Ref: Application: BE/102/18/PL – 312 Chichester Road. Bersted. PO21 5AU

I write to state my objection to the above application being approved for development for the following reasons:

| PROJECT TITLE                                                  |  | DRAWING TITLE                  |                         | No | REVISION | DATE |
|----------------------------------------------------------------|--|--------------------------------|-------------------------|----|----------|------|
|                                                                |  | DRAWN BY<br>AP                 | DRAWING No<br>PA-276-05 |    |          |      |

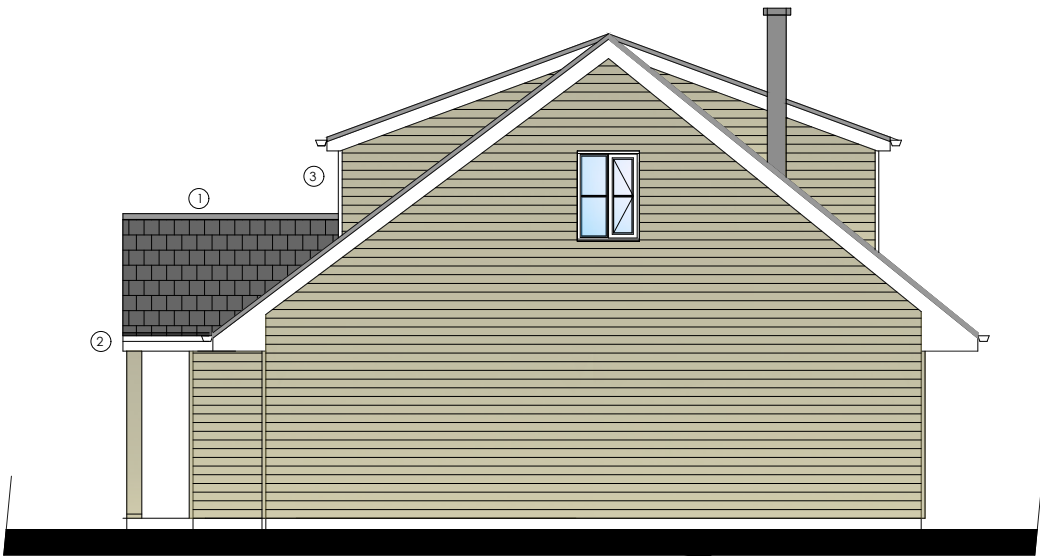
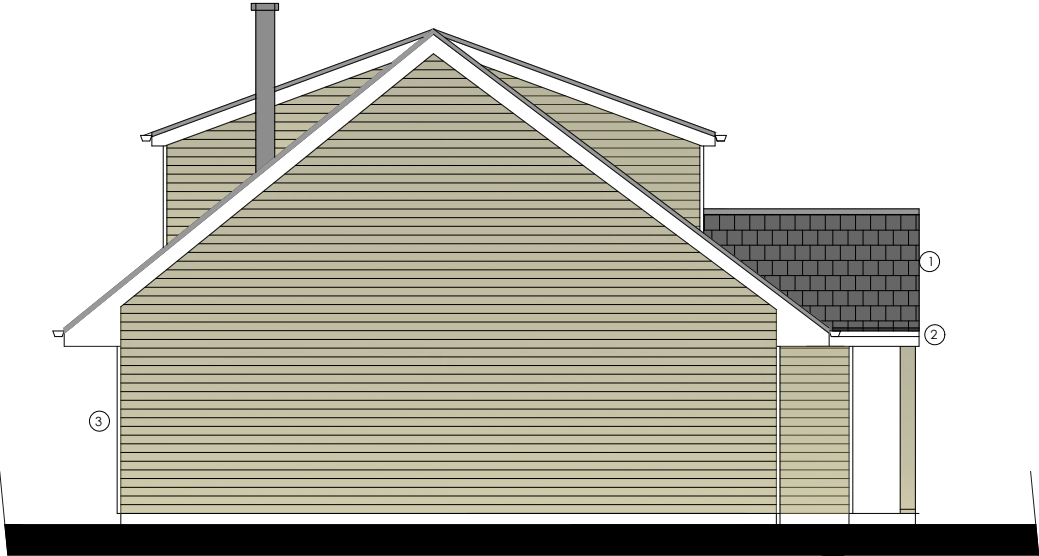
- 3.0 The drawings in plan – Proposed Location PA276.04 show the property being located towards the rear of the garden with the rear walls some 10 metres from the rear property boundary with mine. 3.1 Drawing PA276.04 also shows bedroom 1 to the rear with drawing PA276.05 – Elevations clearly illustrating the size of the window. This proposal clearly provides an overlooking aspect to my property which is contrary to planning criteria
